Planning Officer: Zac Denton
Planning Application Ref: FP/66/18/T
Location: 28 Kingsmead, Felpham
Description of works: Crown reduction of 1No. Holm Oak by 1.5m - 2m & crown raise to 4m
Reasons Given: Affecting neighbouring houses and restricting vehicle access

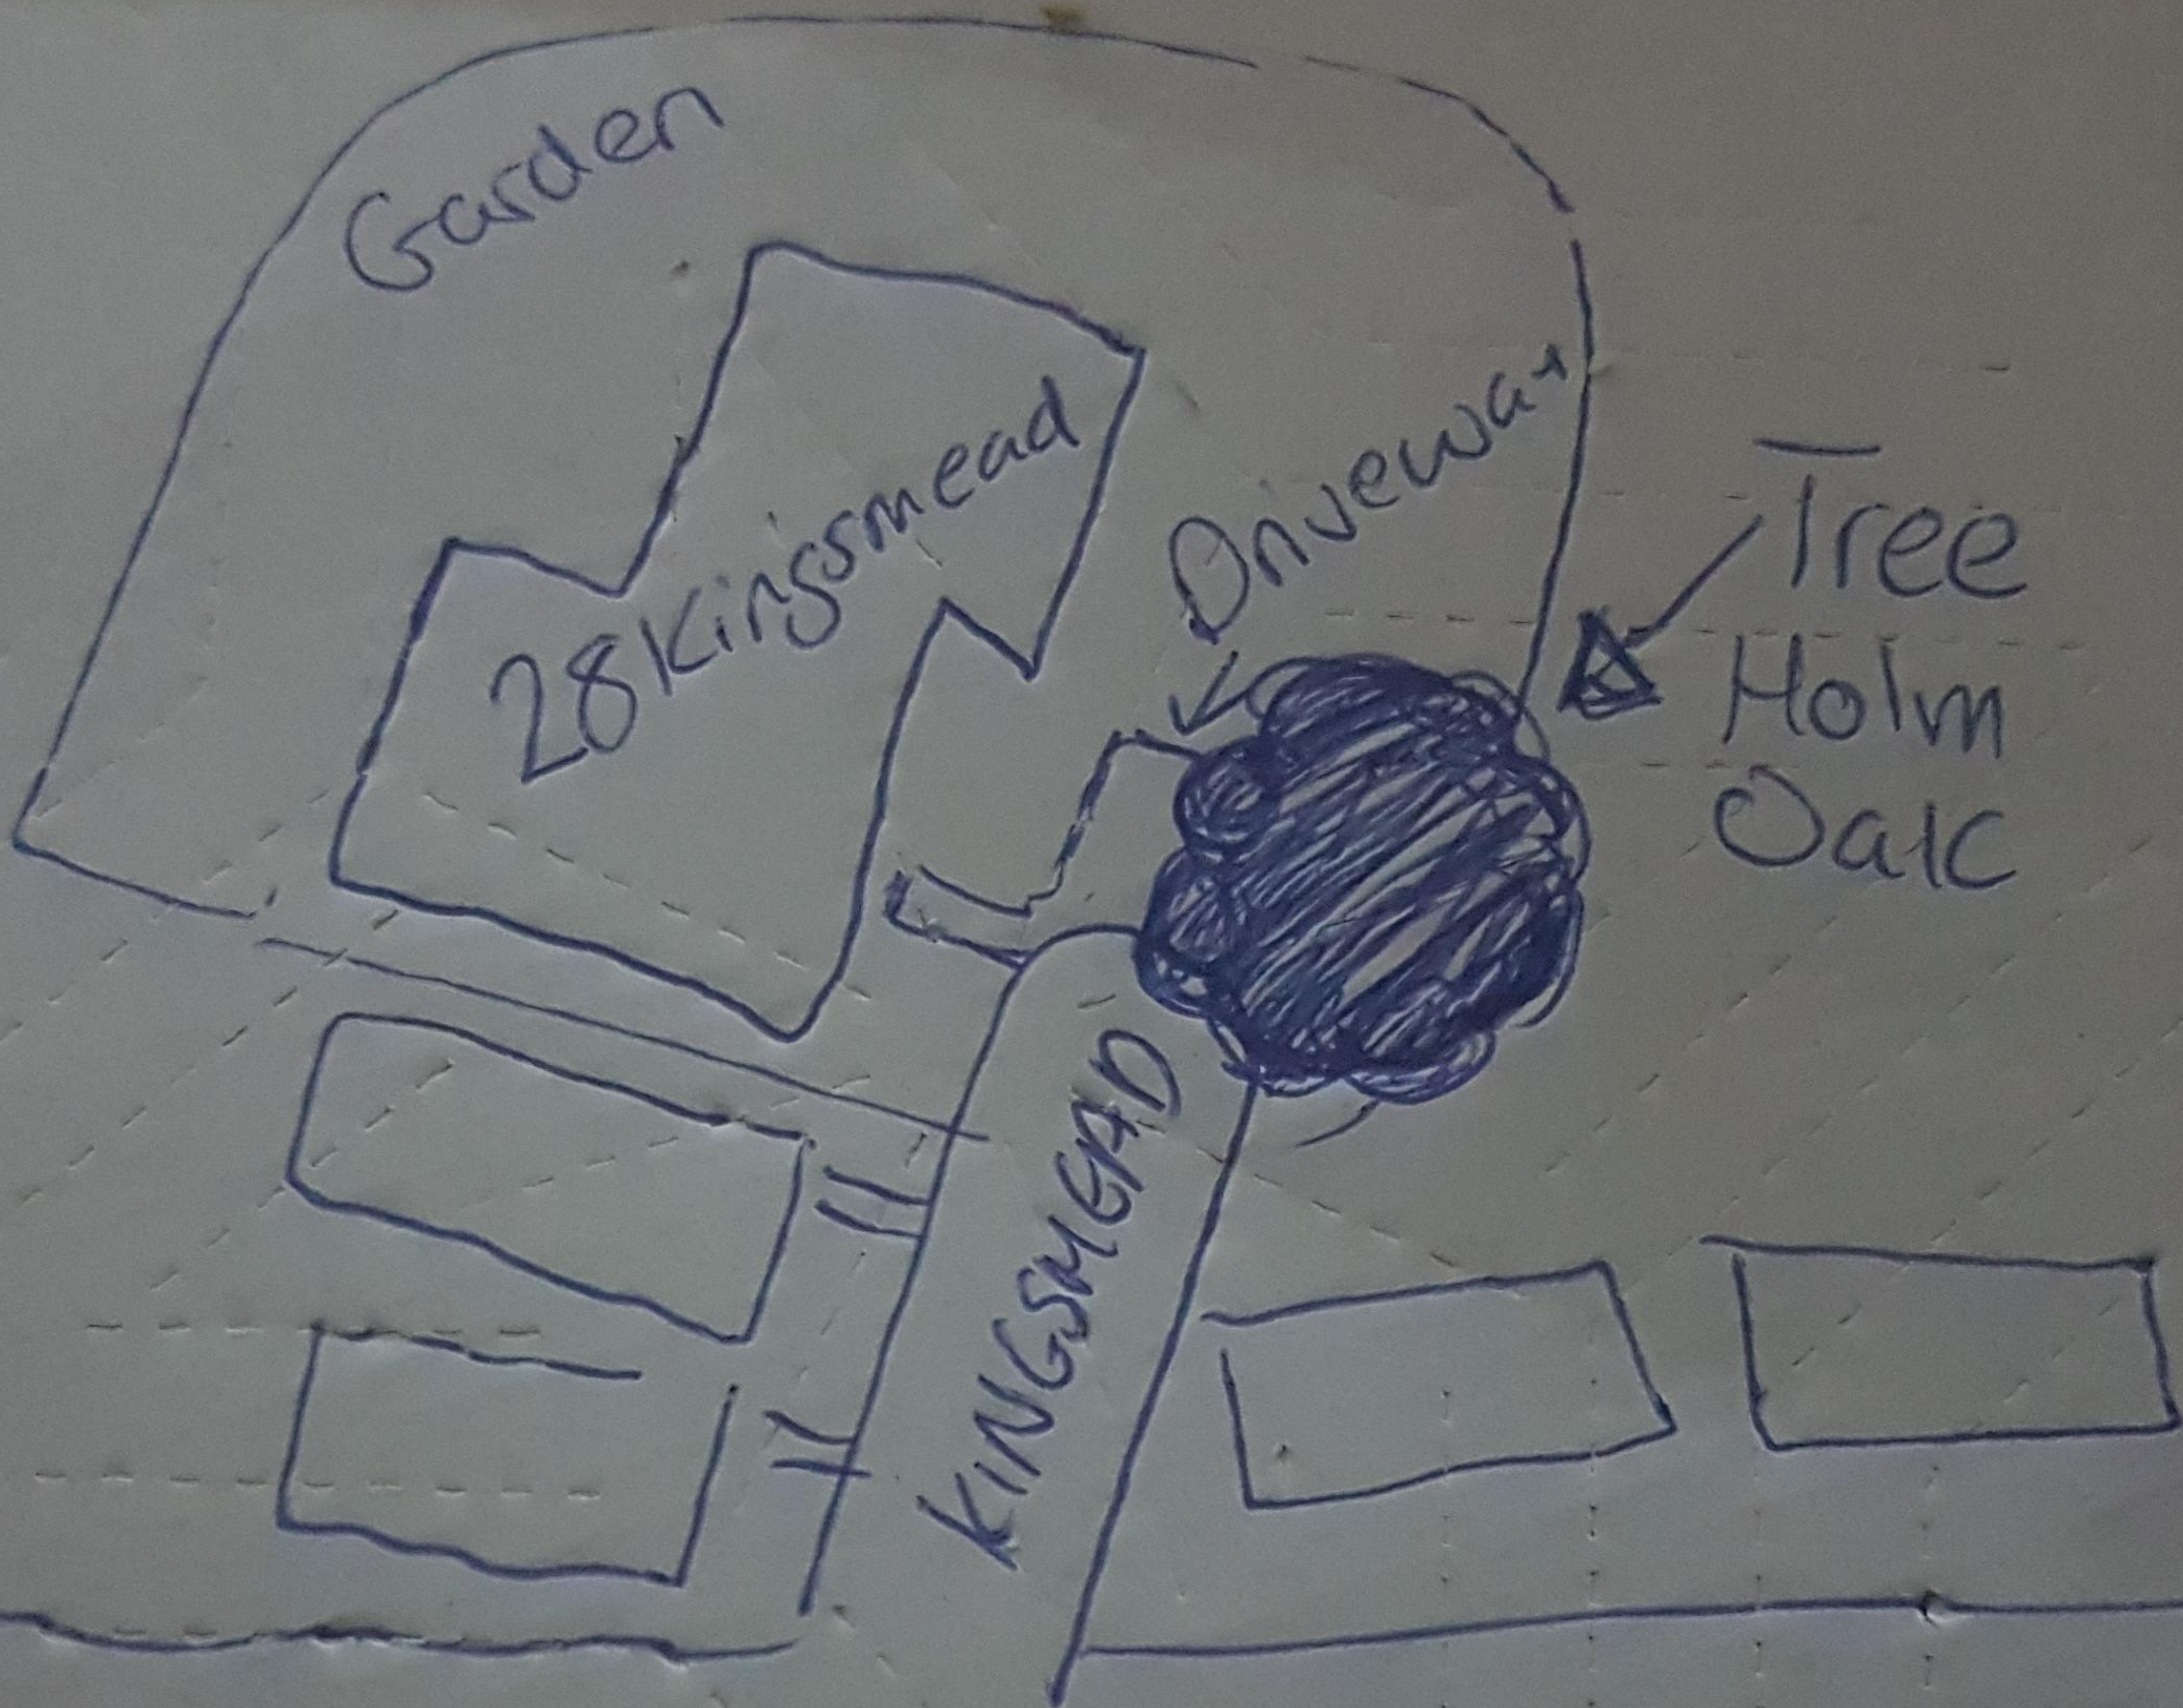
- The work proposed is justified as low growth is at a height that will interfere with the passage of high-sided vehicles and limits reasonable enjoyment of garden areas and maintenance of outbuildings.
- A crown reduction as proposed if undertaken to a high standard; will ensure greater harmony with its surroundings and may provide some benefit in respect of longer-term structural integrity.
- This work is necessary and should not incur a notable diminution of its visual amenity.

- The extent of overhead clearance achieved following branch reduction/removal must not exceed 4metres.
- Where whole branches are to be removed and final cuts made close to the trunk or branch union they are to be made as shown in Figure 2 of BS3998:2010
- Where branches are to be shortened back the final cuts are to be made at the correct angle shown in BS3998:2010 and adjacent to a live bud or lateral.
